**Consultation Response from KC,
Trees****2024/93055 Land Adj, 2, Hopton Hall Lane, Upper Hopton, Mirfield, WF14 8EP****Erection of detached dwelling and associated external works****Date Responded: 20/12/24****Responding Officer: Hazel Irving****Responding Ref: 22/95**

An Arboricultural Method Statement and Tree Protection Plan have been produced by JCA Ltd. [ref. 22345-A]. The survey schedule records four items of vegetation. The tree identified as T1 within the JCA report is subject to TPO Ref. 22/95/t45.

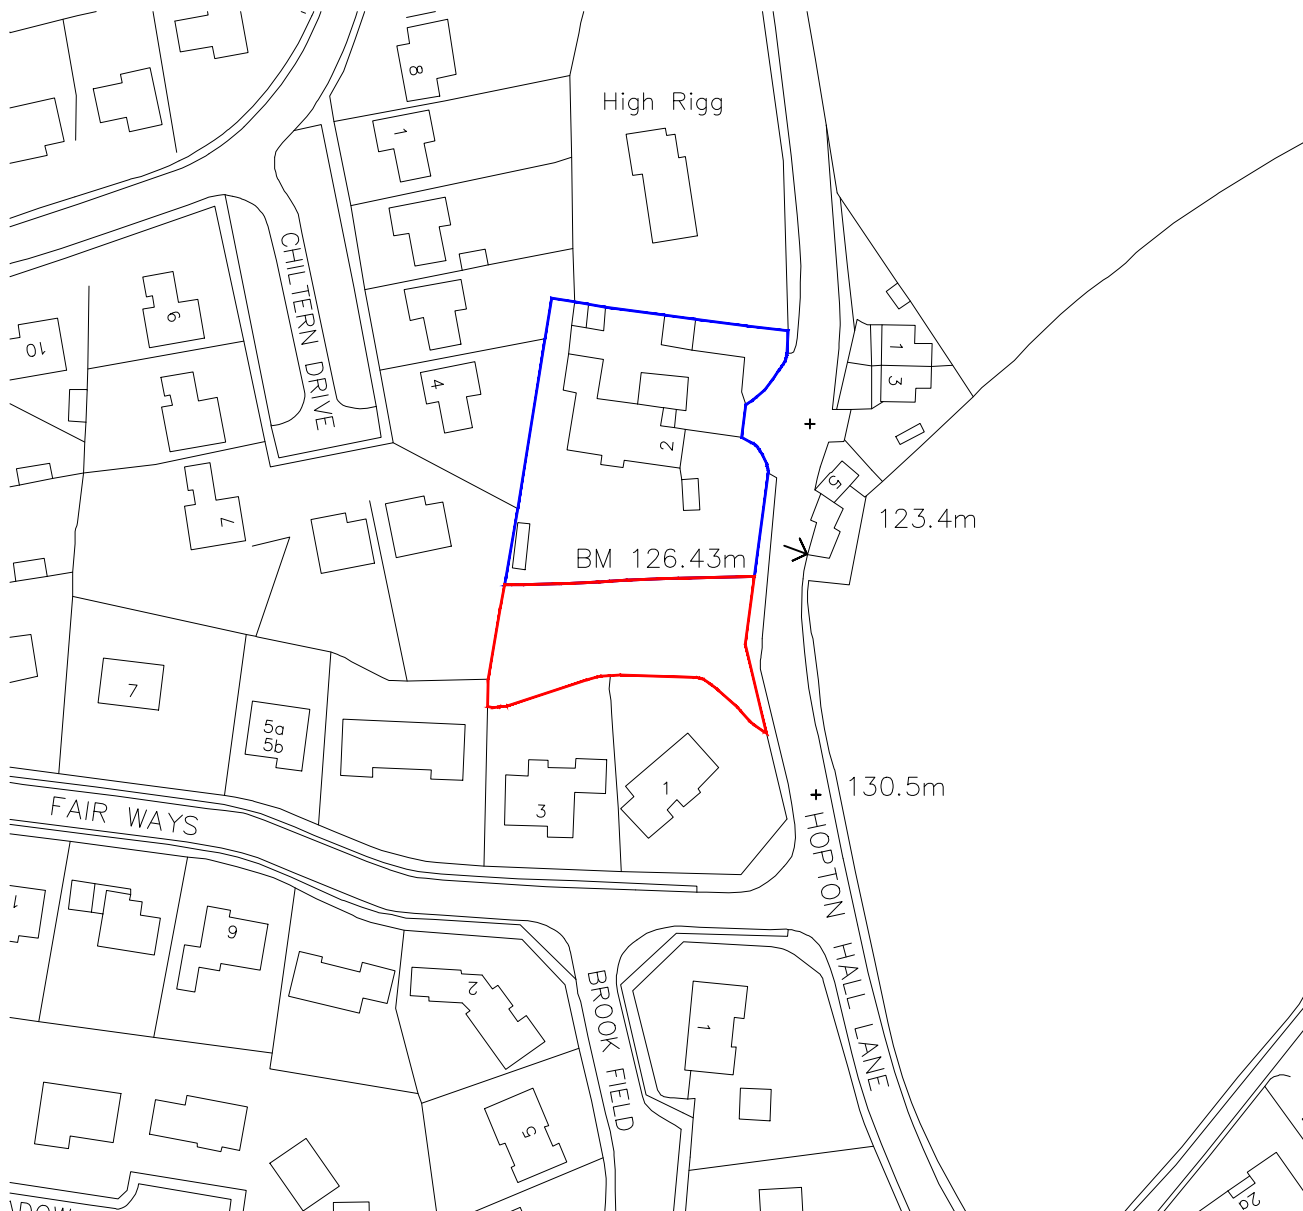
The RPA of T1 tree overlaps with the proposed driveway and access route onto the site. These proposals cause concern as the total overlap of the driveway and access route covers a significant portion of the total RPA. According to BS5837: 2012 new permanent hard surfacing should not exceed 20% of any existing unsurfaced ground within the RPA.

To reduce the tree impacts to protected tree T1 a no-dig methodology is proposed for the construction of the driveway. However, root-pruning is currently proposed for the access route onto the site. The proposed area of root pruning would represent a loss of 11% of the total RPA. This level of root pruning could jeopardise the long-term health of protected tree T1.

To avoid root pruning within the RPA of T1 it is suggested that the area of no-dig construction for the proposed driveway is extended to include the area of the site access. The use of a cellular confinement

system, or suspended driveway would prevent root damage and soil compaction, helping to avoid unnecessary damage to the long-term health of the protected tree.

Ideally the cellular confinement driveway (or similar) would be constructed first to serve as permanent ground protection. This would minimise compaction to the soil as vehicles access the site throughout the remaining duration of the construction phase.

Furthermore, it would be preferable if the tree protection fencing would be realigned once the driveway is completed, in order to protect the edge of the canopy over the new driveway and site access to reduce the risk of any damage to branches in the lower canopy.

Replacement planting is not advisable beneath the canopy of protected tree T1, as digging planting pits close to the stem would further damage the roots of the protected tree.

There is a holding objection from a tree perspective until an alternative solution is submitted to minimise the conflict between the RPA of the protected tree T1 and the proposed site access route.
